WEST SUSSEX COUNTY COUNCIL CONSULTATION

TO:	Arun District Council FAO: Michael Eastham
FROM:	WSCC - Highway Authority
DATE:	27 May 2021
LOCATION:	Land south of Ford Lane East of North End Road Yapton BN18 0DS
SUBJECT:	Y/48/21/PL Construction of temporary vehicular access off North End Road for three years to allow safe access to the affordable units throughout the remaining period of construction within the application site following Y/82/20/RES. This site is in CIL Zones 2 & 3 (Zero Rated) as other development. Additional information received.
DATE OF SITE VISIT:	n/a
RECOMMENDATION:	Advice
S106 CONTRIBUTION TOTAL:	n/a

This is the second WSCC Highways (CHA) response to the above planning application for construction of temporary vehicular access off North End Road for three years to allow safe access to the affordable units throughout the remaining period of construction within the application site following Y/82/20/RES.

DRAWING No: ITB14679-GA-004  
REV: -

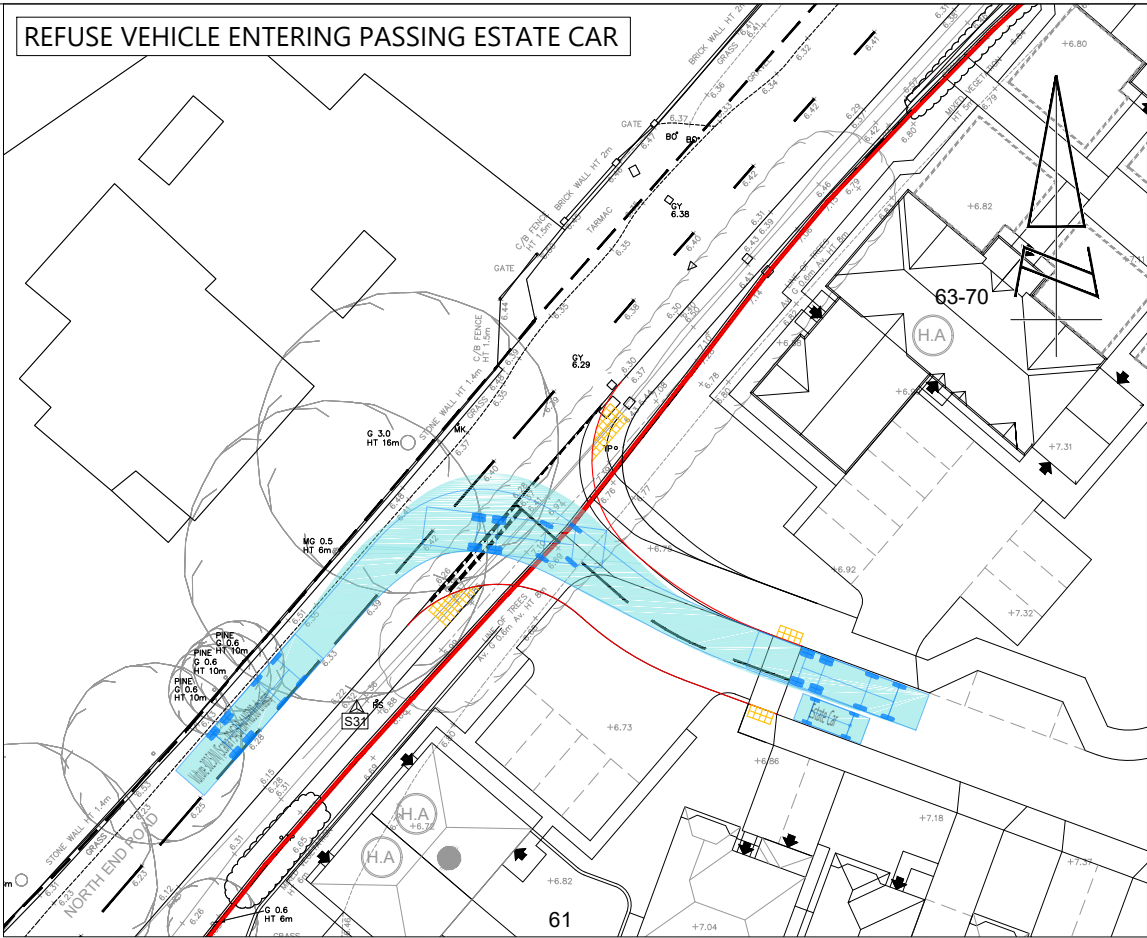
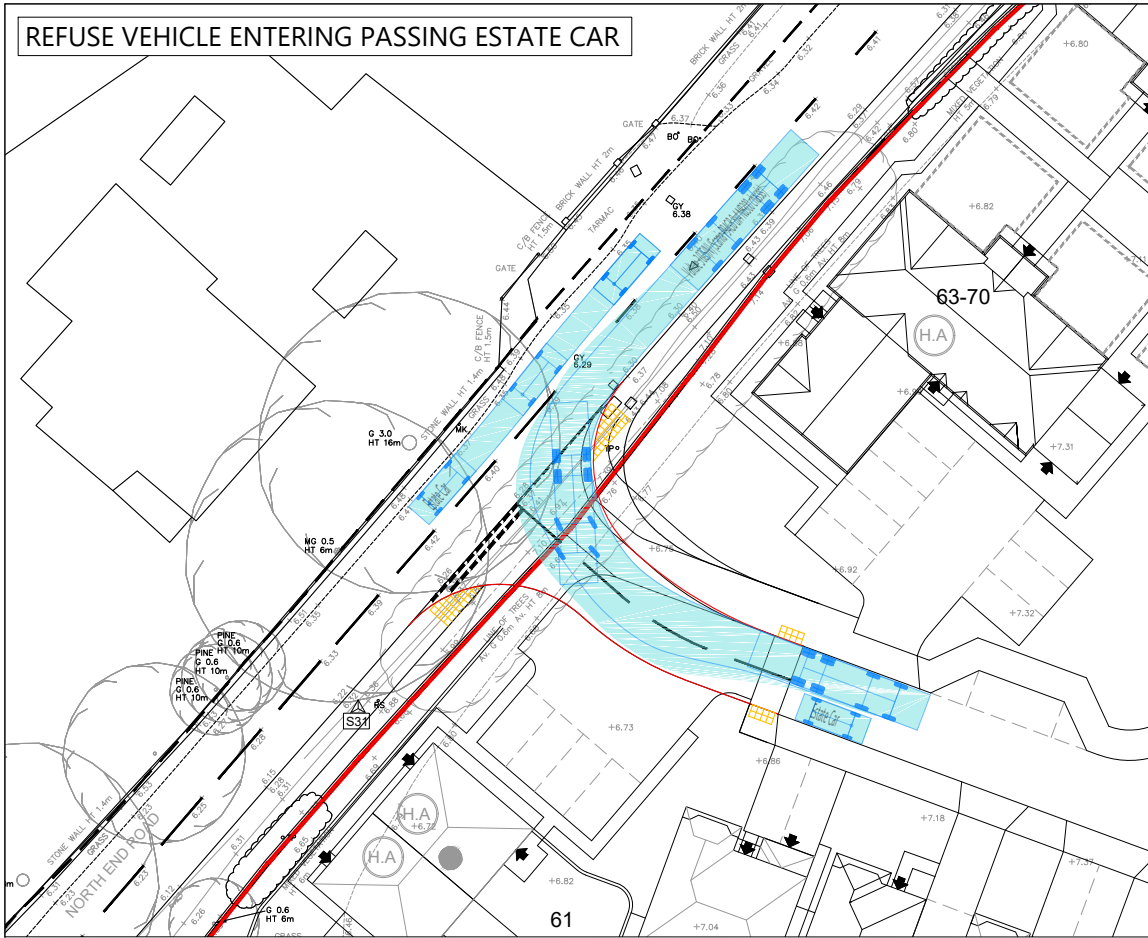
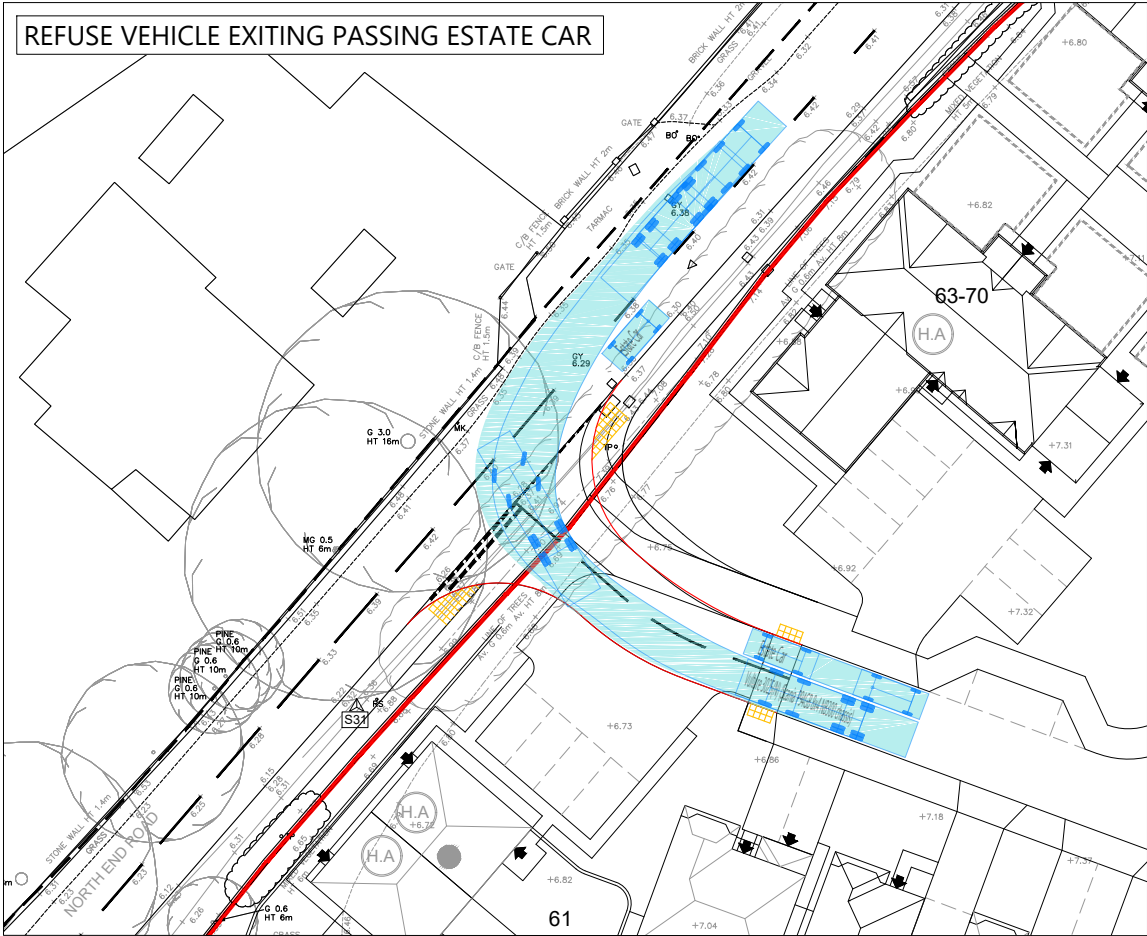
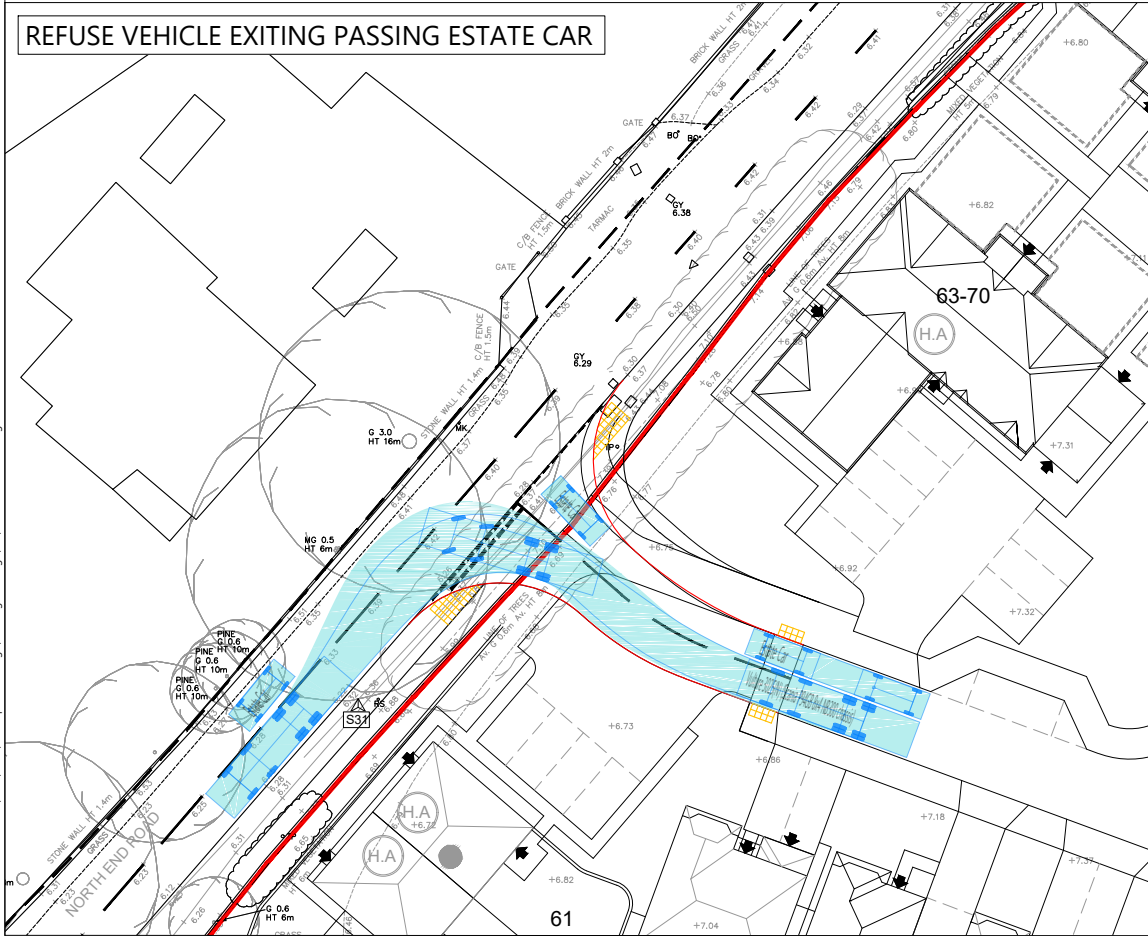
ITB14679-GA-003 Rev B – access arrangements (CAD layers removed) and ITB14679-GA-004 shows further detail of the proposed access.

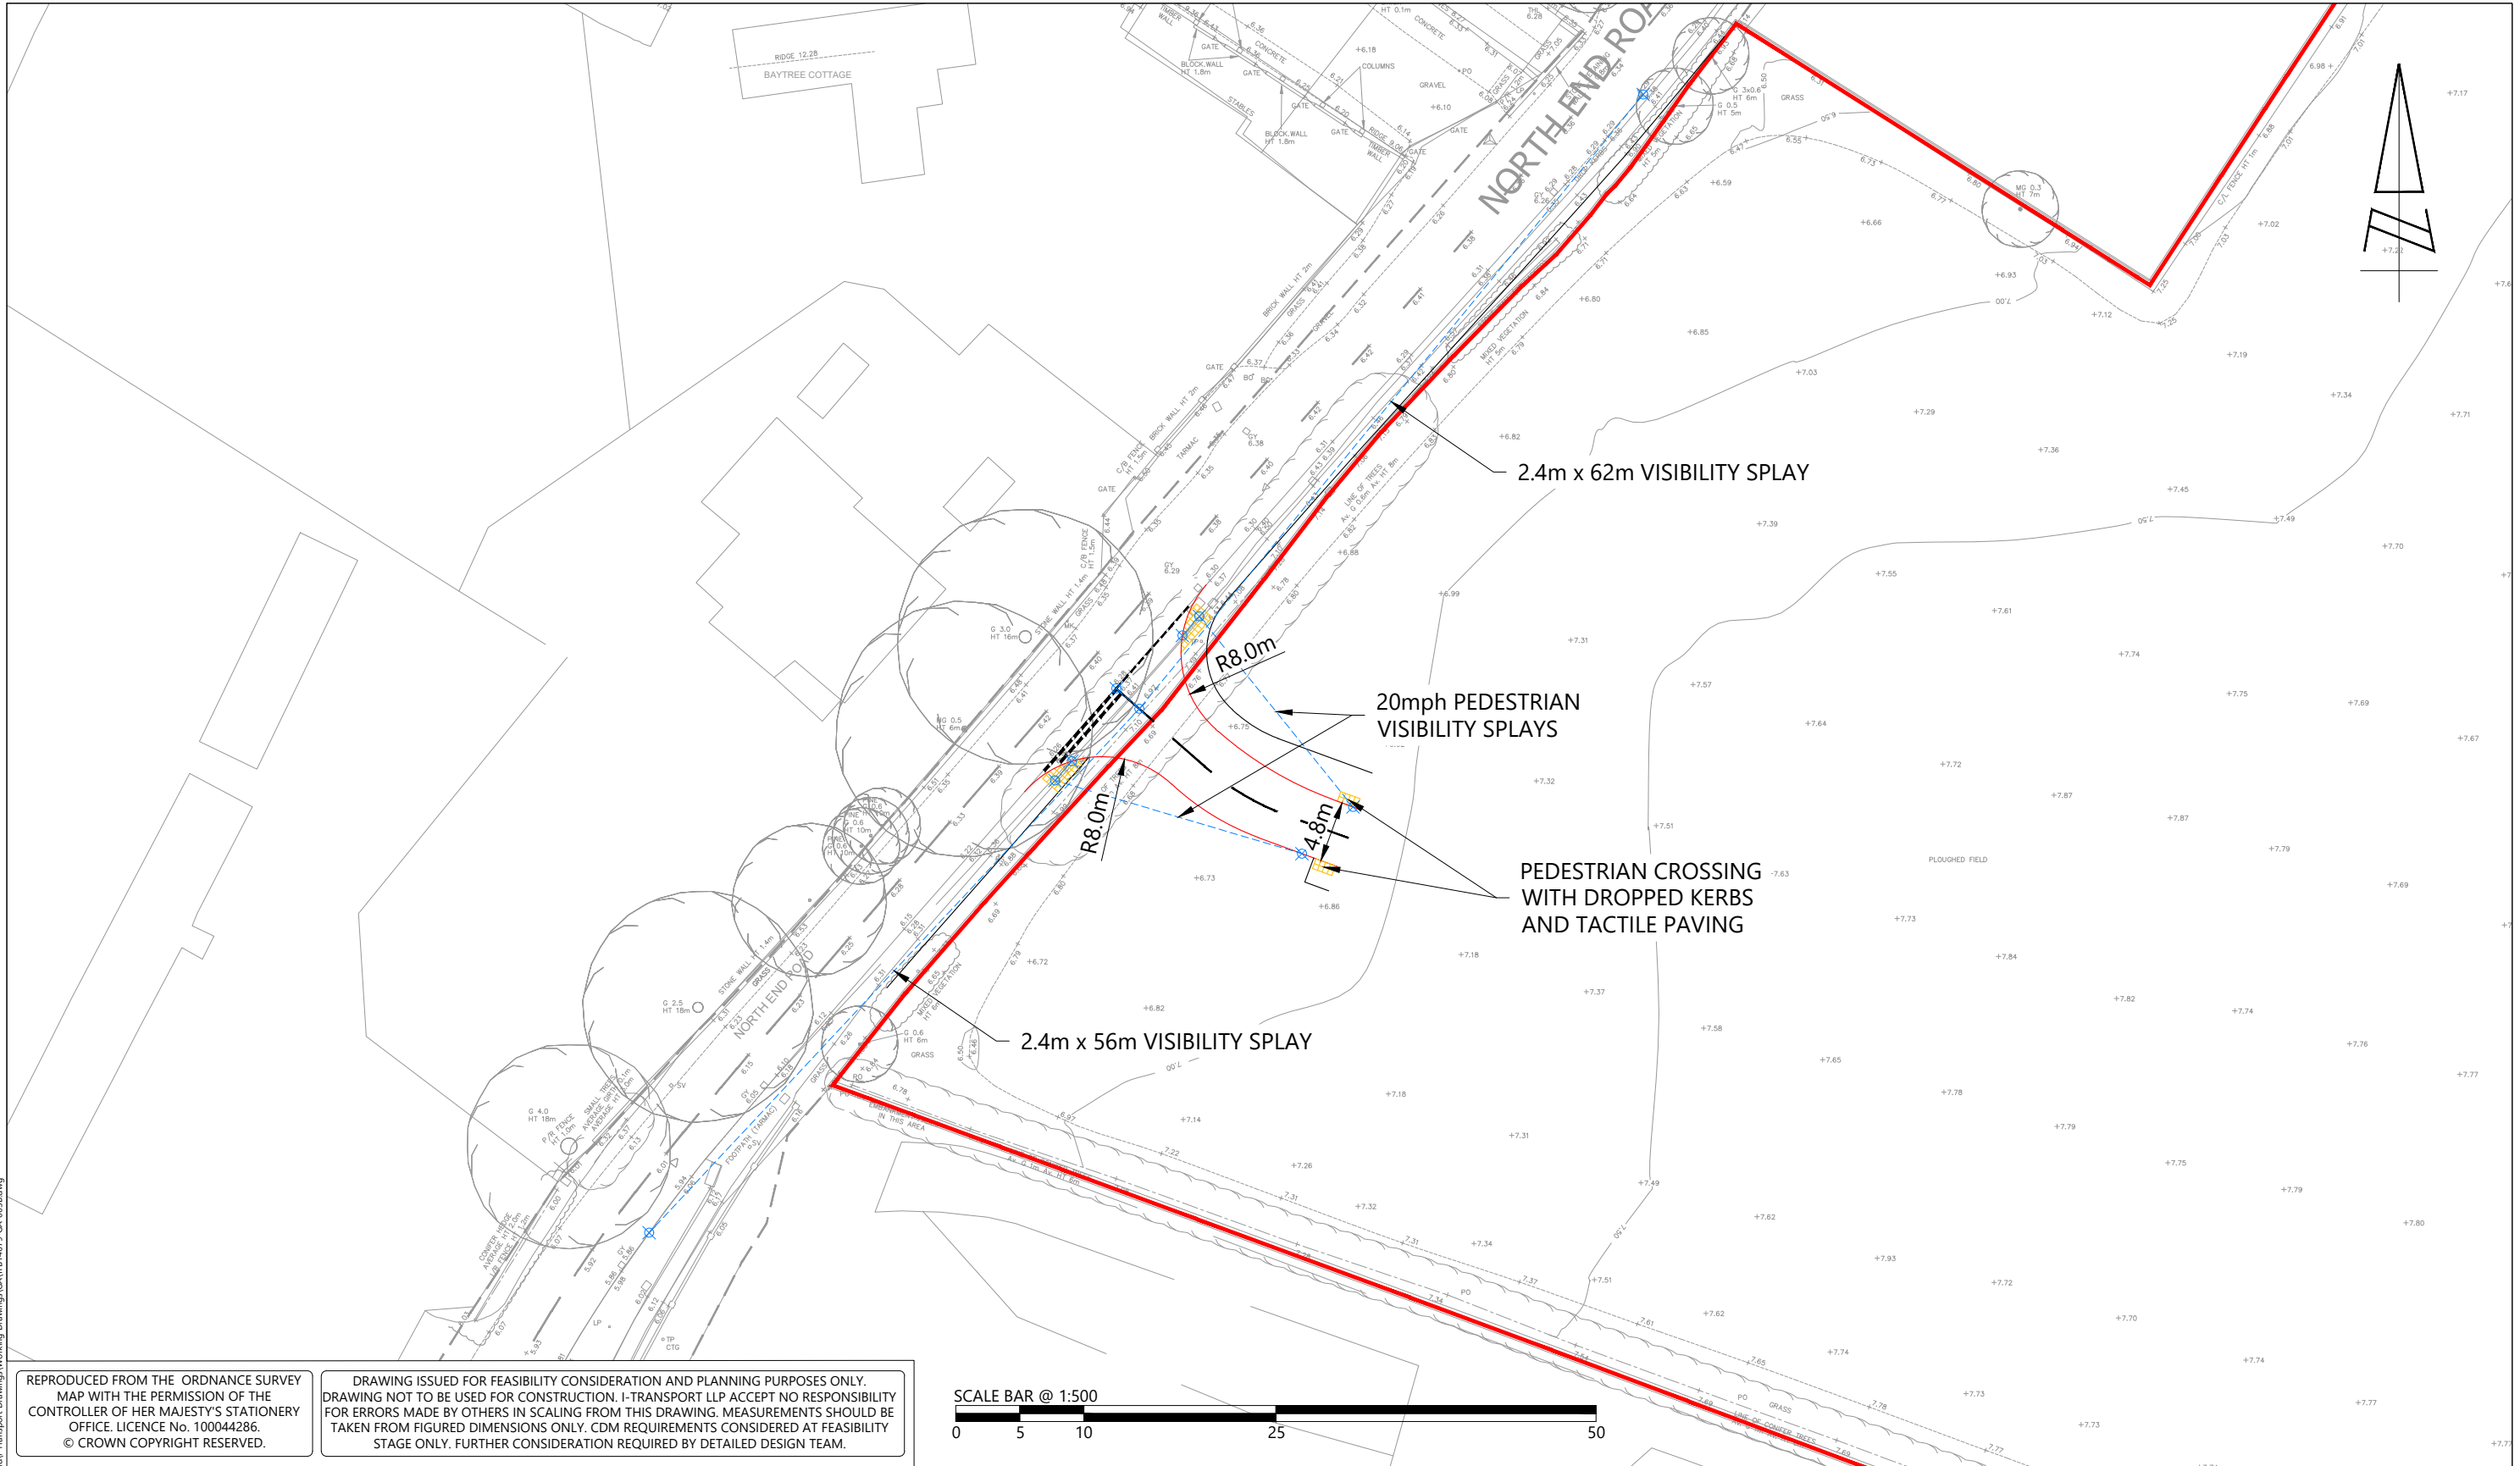
Summary - The trailer of a refuse collection vehicle encroaches the opposing lane where one would not expect it to.

The B2132 North End Road forms a link between the A27 to the north and the B2233 to the south and is subject to a 30mph speed limit in proximity. The road serves a number of direct frontages as well as number priority access in the vicinity. As can be expected, refuse collection vehicles manoeuvre onto and off North End Road at various locations. The proposals subject to this Stage 1 Road Safety Audit include the provision of a temporary simple priority access off the western side of North End Road which accommodates a 6 metre entry radius. The scheme drawings provided with the Audit Brief, include a swept path of a refuse/recycling collection vehicle (RCV) turning left into the proposed access that illustrates the trailer of the vehicle swinging out into the opposing lane as well as encroaching the entire width of the access when undertaking the manoeuvre. Whilst the driver of a RCV will wait within the North End Road carriageway and not attempt to undertake the manoeuvre when a vehicle travelling along the access road approaching the give-way, a northbound vehicle would not expect the trailer of the RCV to swing out into their path when passing which could lead to sideswipe or loss of control type collisions.

It is recommended that a slacker inside corner radius is provided.

Summary - Heavy goods vehicles encroach the opposing lane where one would not expect it to.

The B2132 North End Road forms a link between the A27 to the north and the B2233 to the south and is subject to a 30mph speed limit in proximity. The proposals subject to this Stage 1 Road Safety Audit include the provision of a temporary simple priority access off the western side of North End Road that serves an access road that is 5.5 metres wide which reduces to 4.8 metres after circa 16 metres with a 20 metre inside radius. The scheme drawings provided with the Audit Brief, include a swept path of a refuse / recycling collection vehicle (RCV) turning into the proposed access that illustrates the vehicle encroaching the entire width of the access and part of the access road where the carriageway reduces, when undertaking the manoeuvre. Whilst the driver of a RCV will wait within the North End Road carriageway and not attempt to undertake the manoeuvre when a vehicle travelling along the access road approaching the give-way, the driver of a westbound vehicle is unlikely to expect the RCV to encroach their path at this location which could lead to sideswipe or loss of control type collisions.

It is recommended that a slacker inside corner radius is provided.

Summary - No level access is provided for pedestrians to cross the proposed access road.

layout with a 4.8 metre wide access road that benefits from a 2.0 metre footway both sides of the carriageway. The Audit Team is unaware if the illustration is the layout that will be in place for the temporary three year period when the proposed access is to be in use, however, no crossing point is provided to allow pedestrians level passage between the southern footway and northern footway that connects to the existing footway network which is highly likely to form a desire line.

It is recommended that a dropped kerb crossing point with tactile paving is provided.

Accepted – the swept path analysis has been adjusted and as illustrated on Drawing ITB14679-GA-003 Rev B to provide for a 8m radii on both sides of the access road. A RCV can turn left into the access road without the trailer encroaching the opposing lane to the extent that it would obstruct oncoming traffic as shown in drawing ITB14679-GA-004. The vehicle encroaches the entire width of the proposed access road, however, this is common practice and the drivers of such vehicles do not commence their journey unless it is clear to do so.

Agree with Audit recommendation and Design Organisation's Response. Larger bellmouth radii of 8m to be provided at the point the access joins North End Road.

Accepted – the radii of the junction has been increased to 8m. The plan that was utilised for the swept path analysis included a 3.0 metre footway cycleway along the northern side which is to be retained as part of the permanent arrangements at this location; the width has been reduced to 2.0m for a short distance to accommodate the manoeuvre. As noted on the previous matter, the RCV does take up the entire width of the carriageway within the site, however, such movements are infrequent and a common occurrence in such locations across the local area. There is no evidence such manoeuvres result in a highway safety issue. Within the site, the RCV does not cross then re-cross the centre line, a manoeuvre which may otherwise be unexpected.

Agree with Audit recommendation and Design Organisation's Response. Larger bellmouth radii of 8m to be provided at the point the access joins North End Road.

Accepted – the identified matter relates to the permanent layout of the site and therefore may not present during the lifetime of the temporary access. Notwithstanding, should footway be introduced on both sides of the access road while the access is in situ, a pedestrian crossing point will be provided as shown in drawing ITB14679-GA-003 Rev B.

Agree with Audit recommendation and Design Organisation's Response.
